From: Simon Davis
Sent: 05 June 2020 11:29
To: Tim Rodway | Rodway Planning [REDACTED]
Subject: RE: BR/99/20/PL

Subject: BR/99/20/PL

PROPOSED GROUND FLOOR PLAN

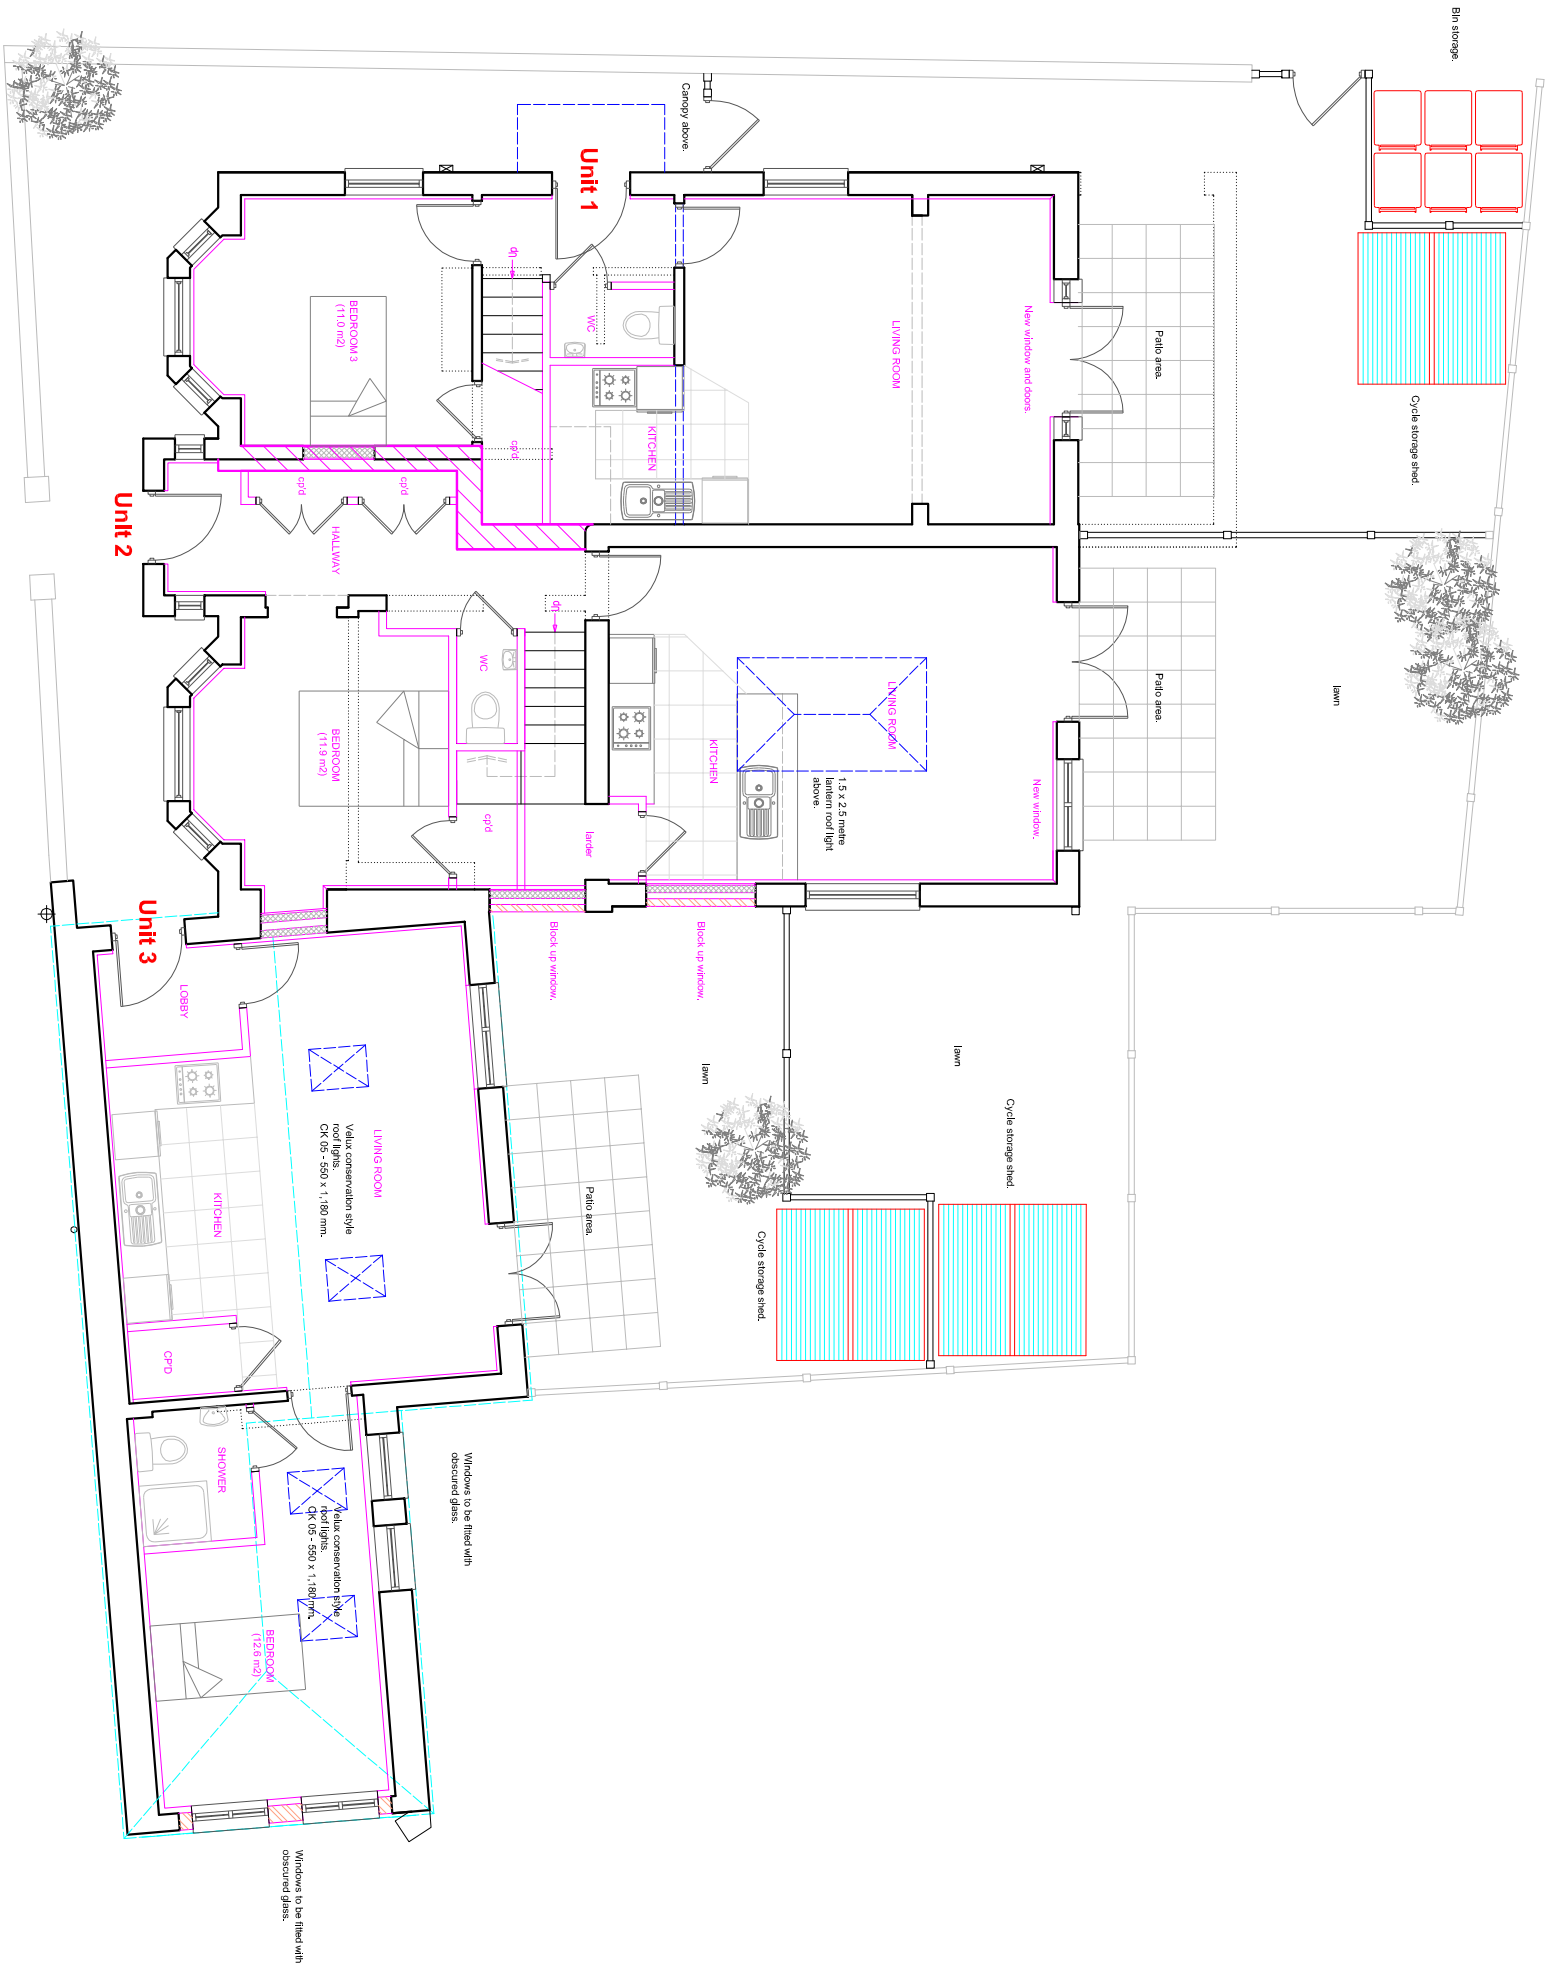
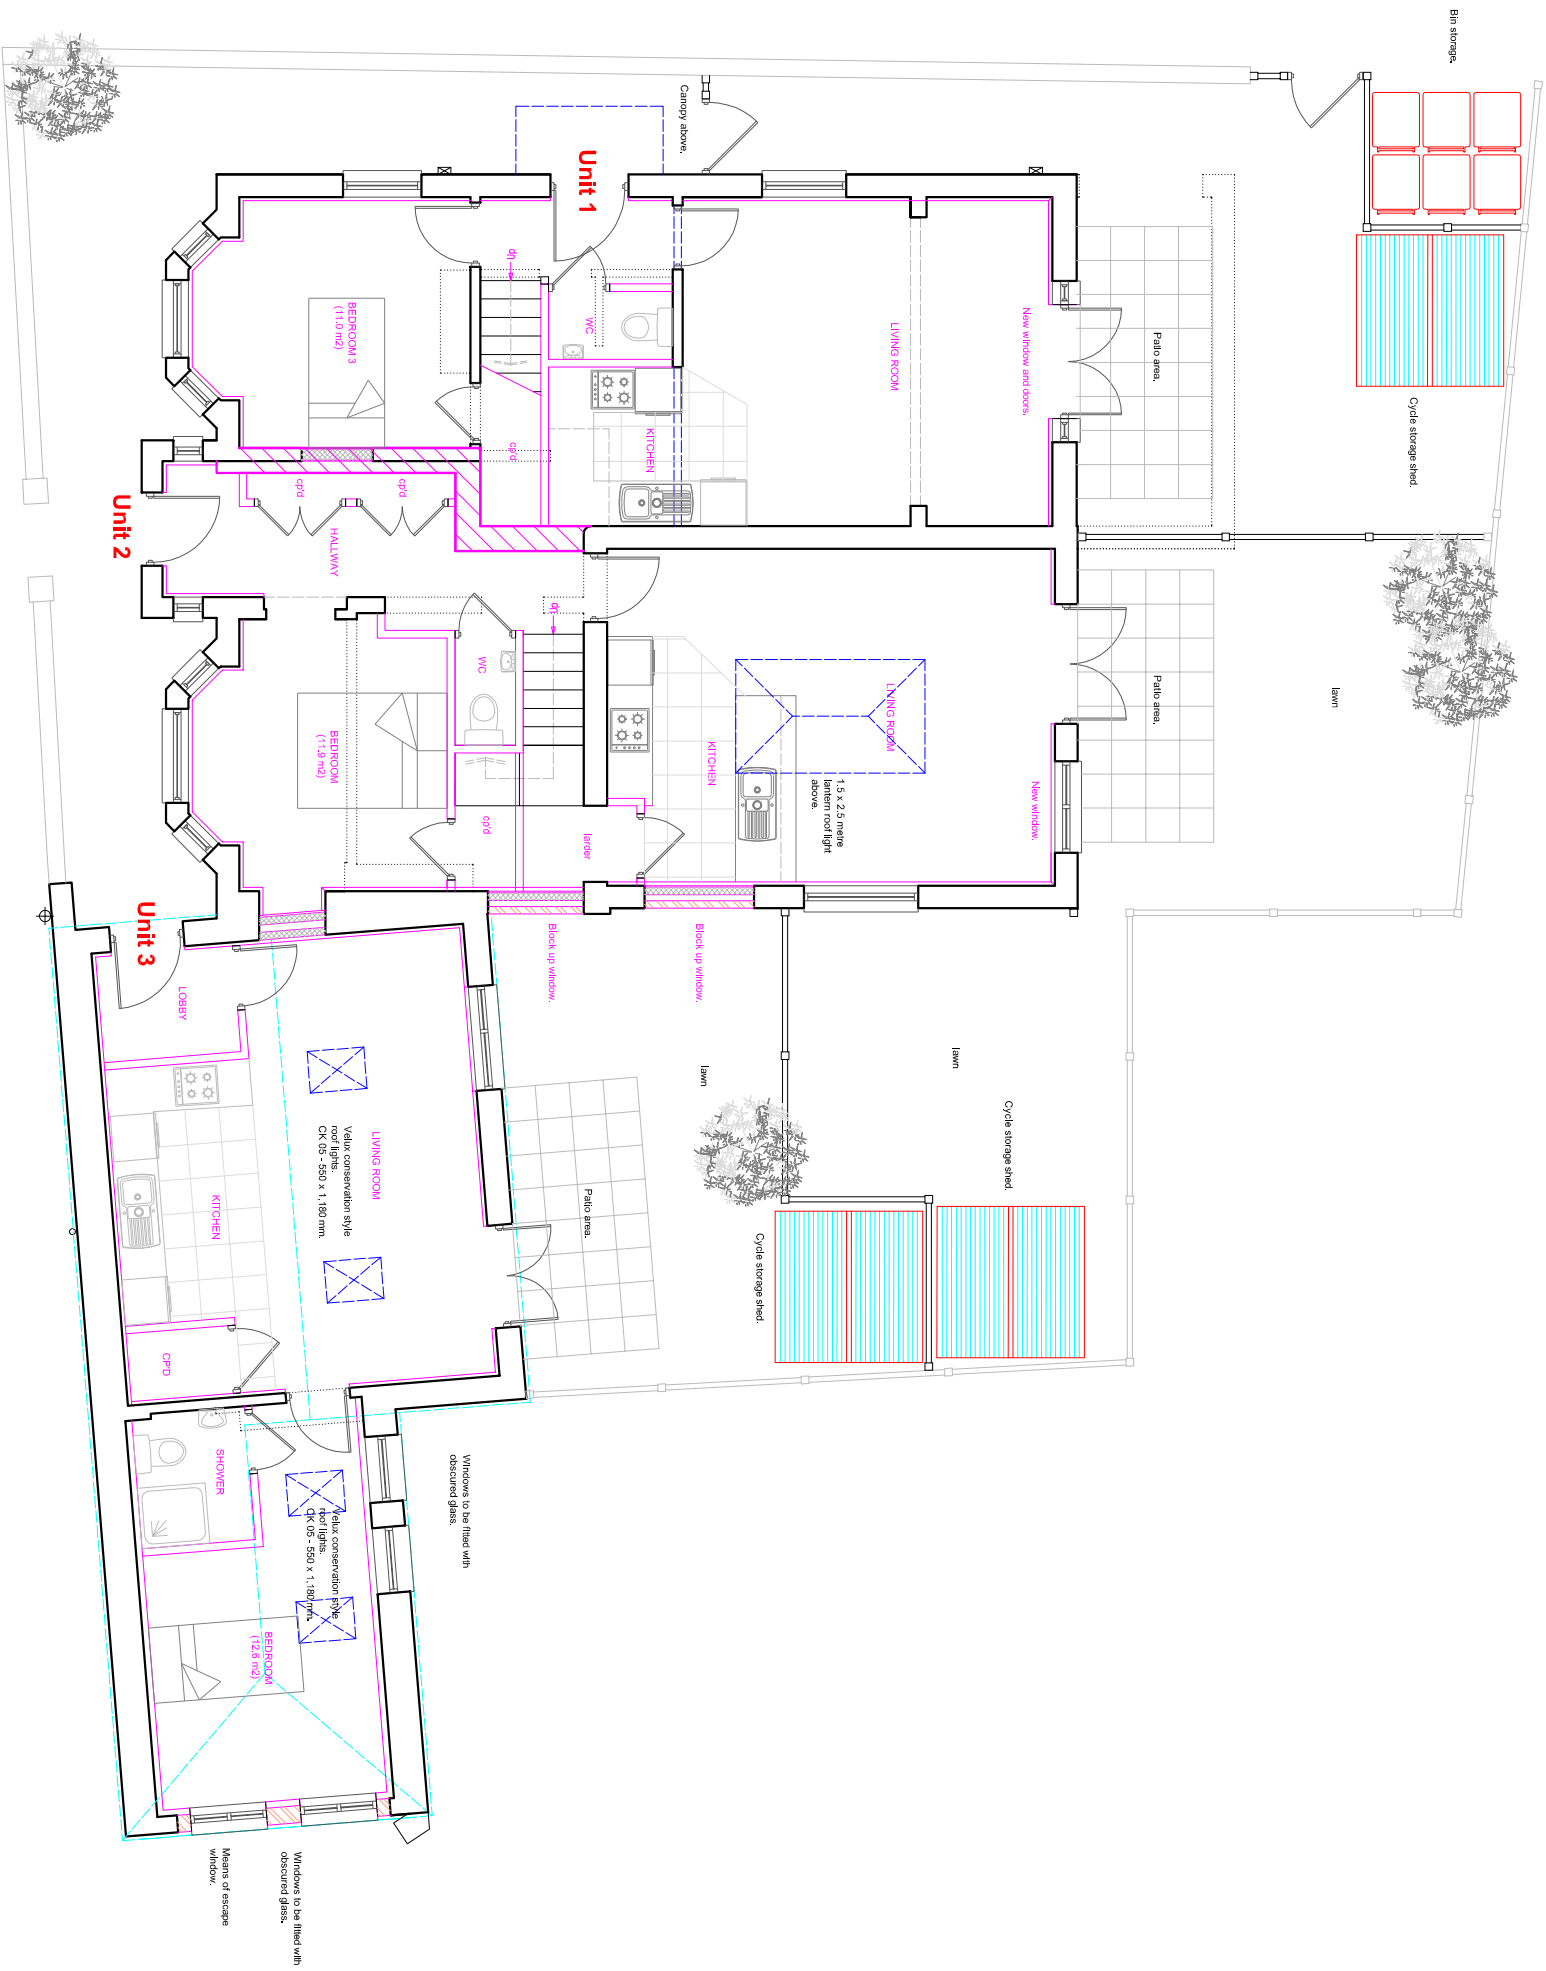
Please see comments of our EH HMO Officer. These are mostly for information but I don't know whether you need to amend the plans re having an escape window for unit 3?

"An escape window with a sill height of not more than 1100mm from finished floor level, with an unobstructed openable area of 0.33m² and have a minimum 450mm height and 450mm width must be provided in the bedroom of unit 3."

"A window serving the bedroom to Unit 3 would need to be capable of means of escape in case of fire under The building Regulations in any case – the minimum clear area must be 0.33 m2 with no dimension (vertical or horizontal) being less than 450 mm. Cill height is to be between 800 and 1,100 mm from internal floor level.

The casements sizes are fairly narrow – if a single casement does not give the 450 mm width, the window will need to open as a whole (fixed mullion) but the look can remain the same.

I attach a copy of the plan with means of escape window marked on."
